REPORT UPDATE

Application No: A/23/15/PL

REF NO: A/23/15/OUT

LOCATION: Land south of New Road (A259) &
East of Brook Lane
Angmering

Title
HIGHWAY ACCESS PLAN

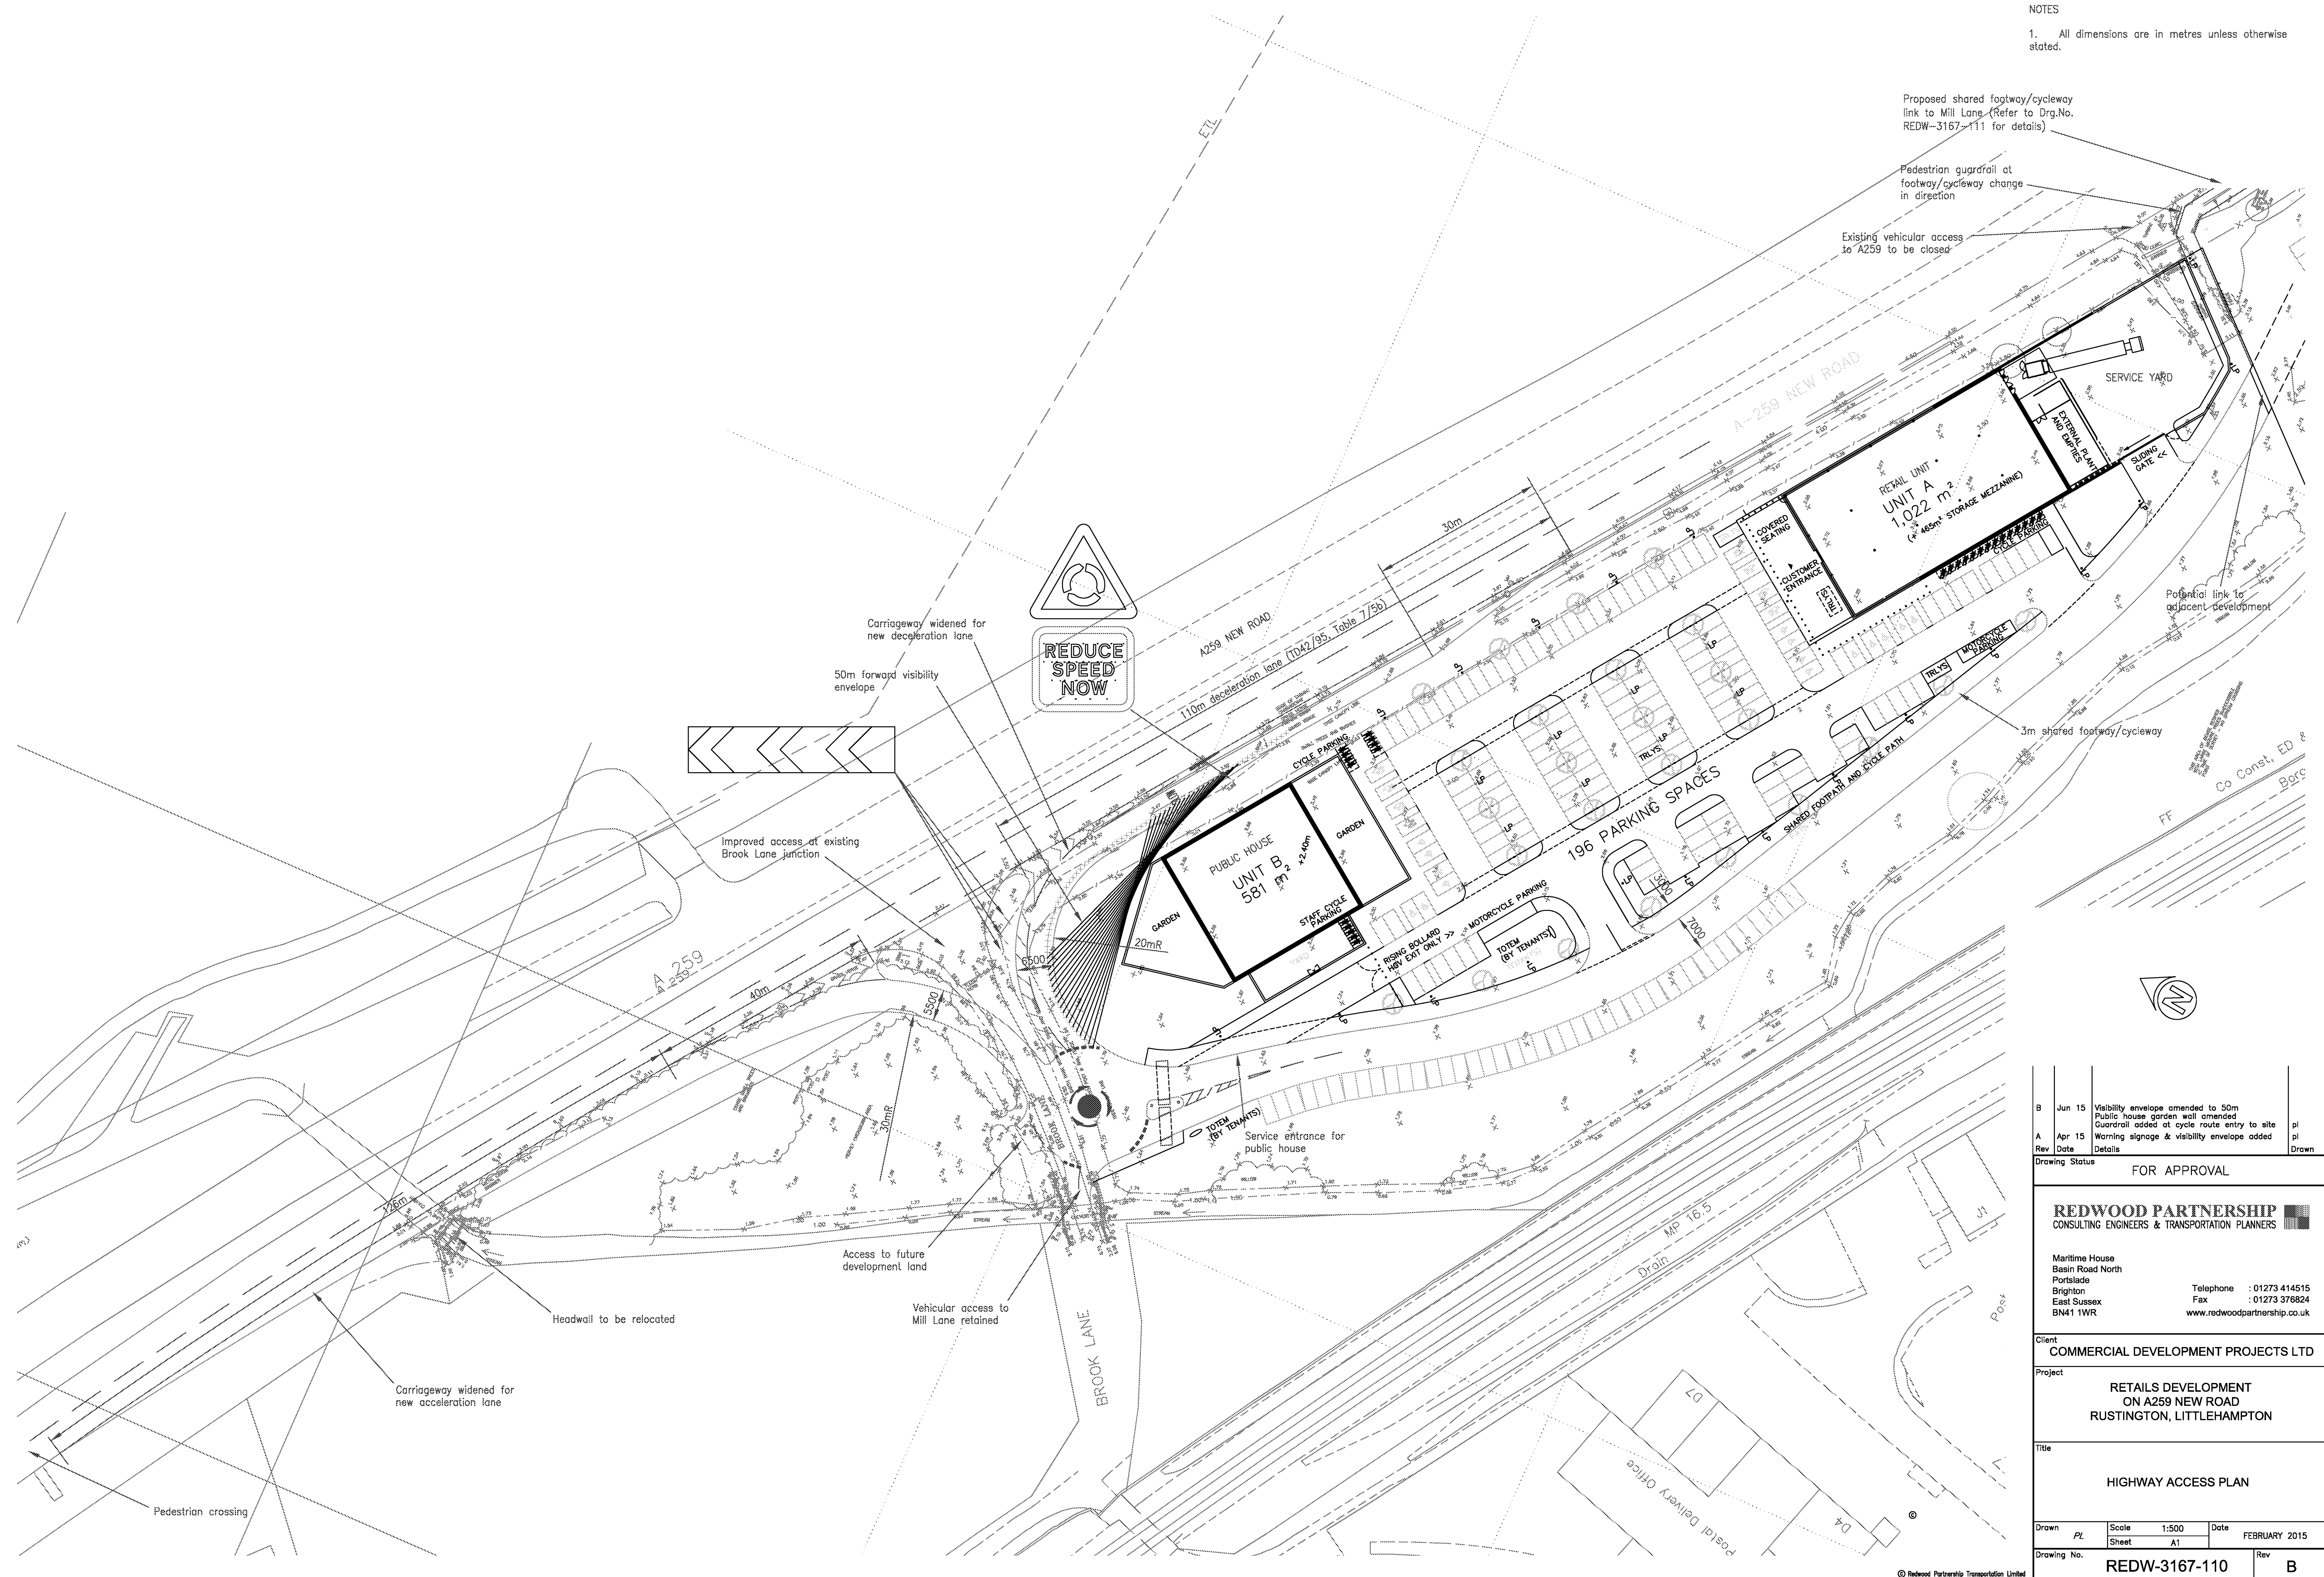
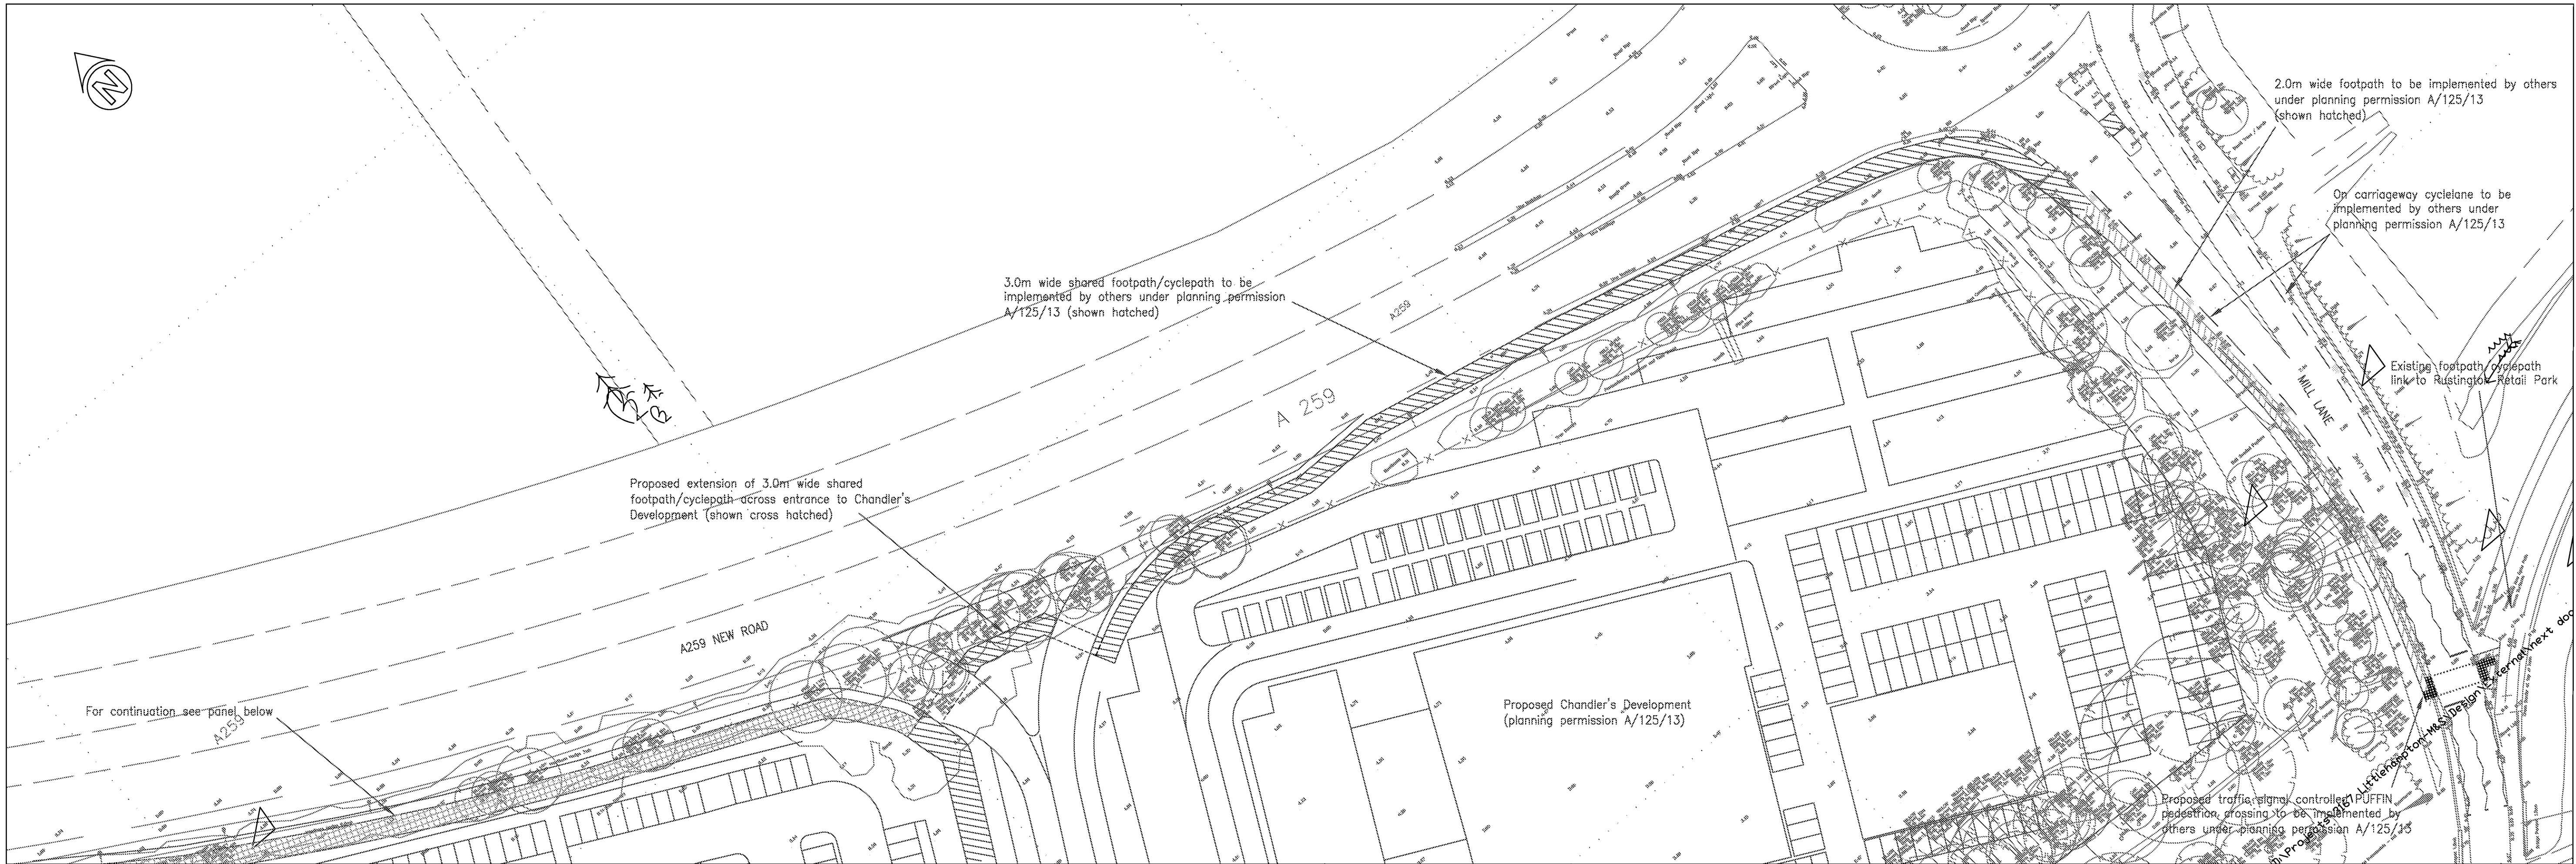
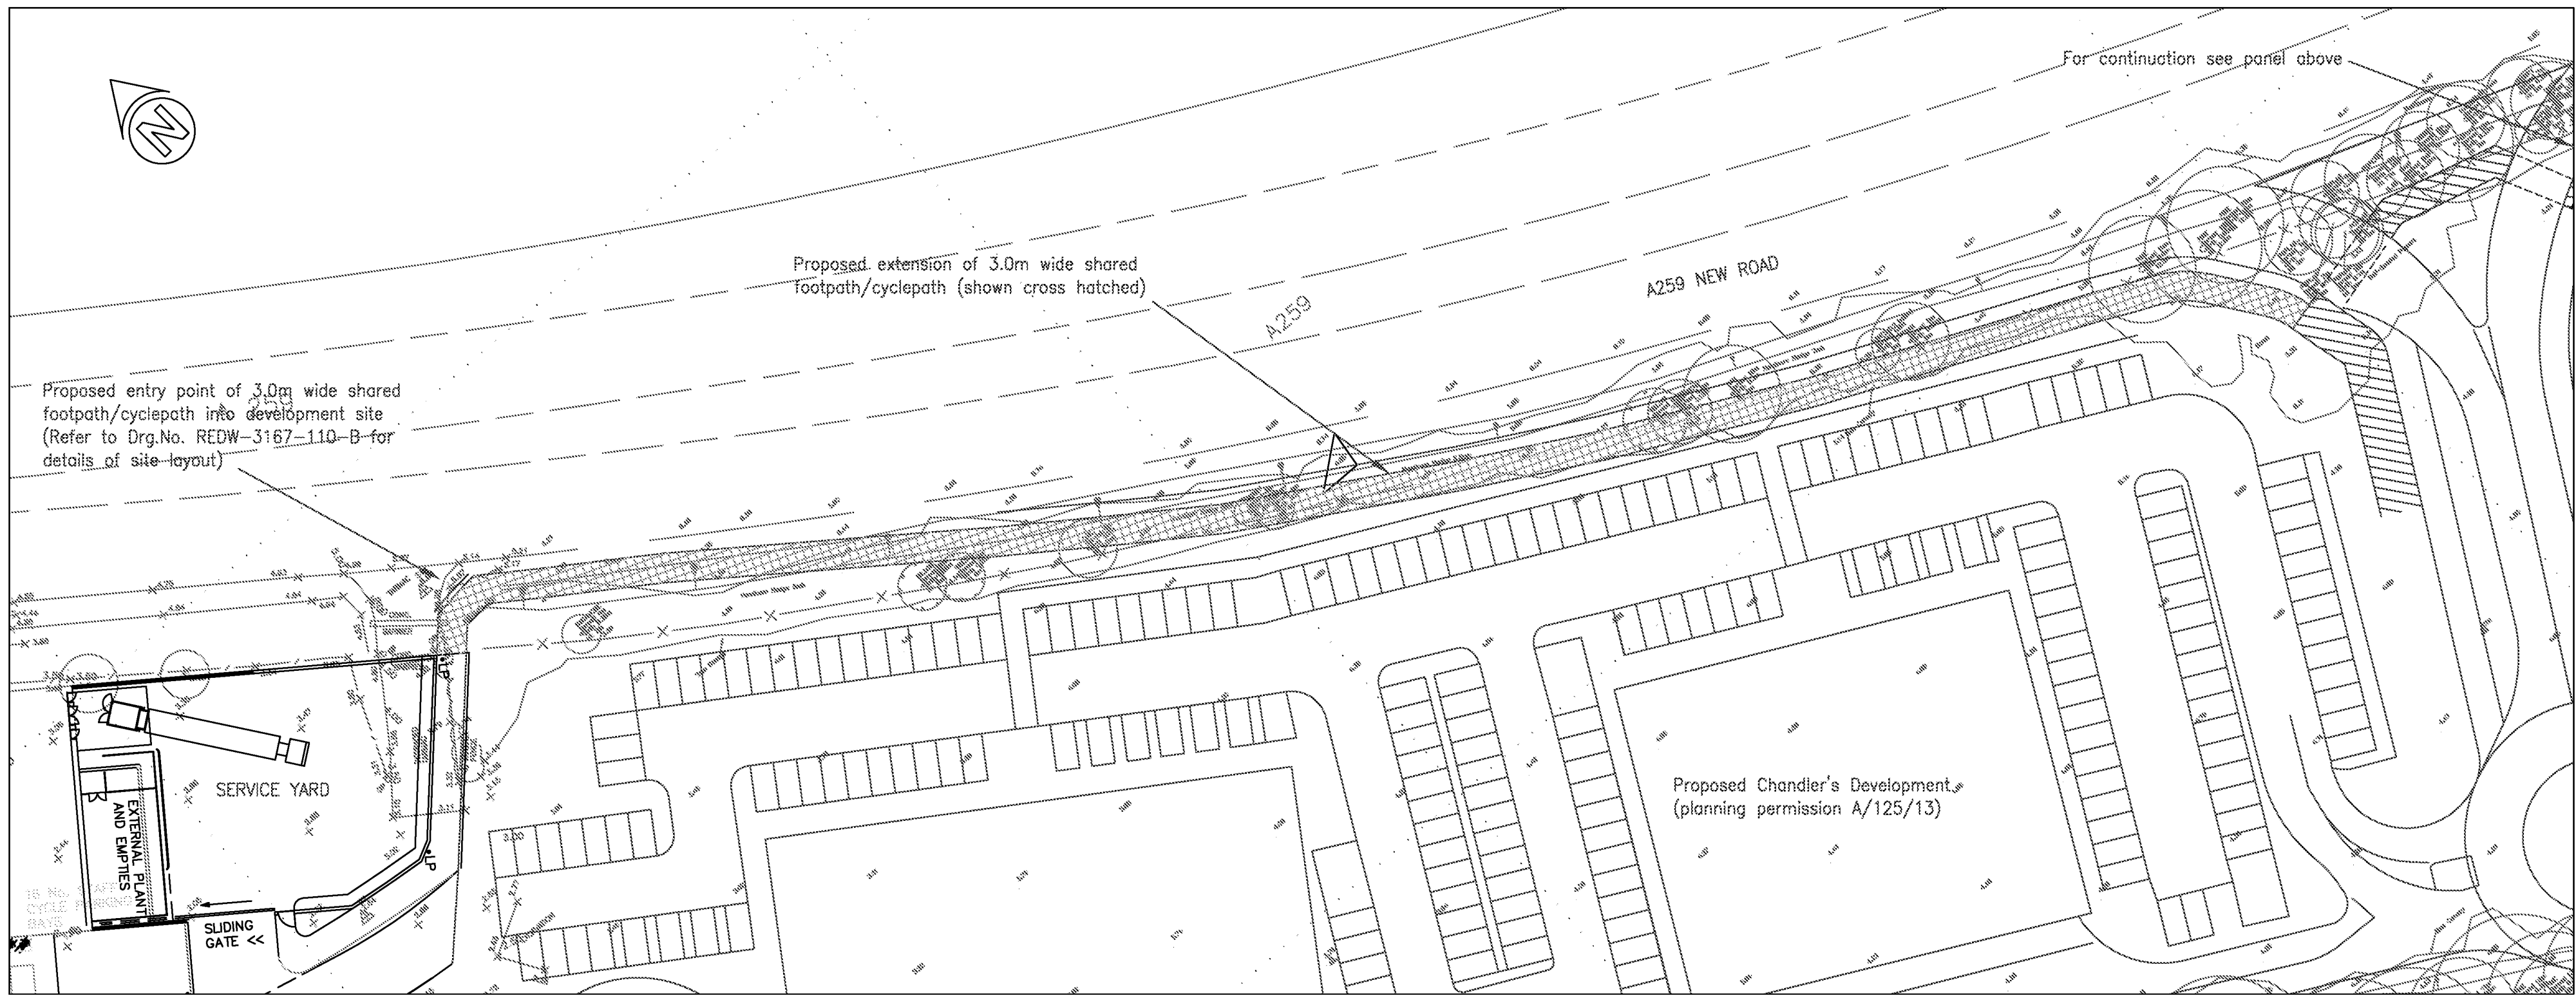
- The proposed layout is not consistent with the consented residential/ care home scheme and applicant should demonstrate how it does not prejudice the development on the adjacent site – a revised plan is required for the access. The S106 Agreement and a condition should secure access to the consented scheme.

Local Highway Authority: Confirm that the revised drawings for the access now demonstrates that there is potential for the access to be provided to facilitate access to the site to the west. Request for conditions addressing the following matters:

The access plan for the application has been amended and the potential link to the committed scheme A/169/17/OUT to the west of the site has been improved (Highways access plan REDW-3167-135). The LHA are satisfied that the access shown does not preclude the consented scheme from coming forward and therefore do not object. However, the proposed roundabout layout for this proposal and the adjacent access (considered under A/83/18/RES) have slightly different alignments, which would prevent one scheme being implemented. A further revised plan (REDW-3167-137) has been submitted which further amends the access plan to align with the one proposed under A/83/18/RES. There are still slight differences (with this proposal seeking a slightly larger radius roundabout). However, it is considered that the proposals could both be implemented. This would allow one satisfactory, safe and secure access to be constructed for the both schemes in accordance with Policy T SP1 of the ALP.

The access has been revised to take into account the access required to the consented development on the adjacent land. This initially resulted in two similar, but not identical roundabout proposals which would allow access to both sites. The applicants have confirmed that as the LHA has confirmed that either access proposal would be suitable, that they are proposing to amend their access to accord with that proposed under application A/83/18/RES.
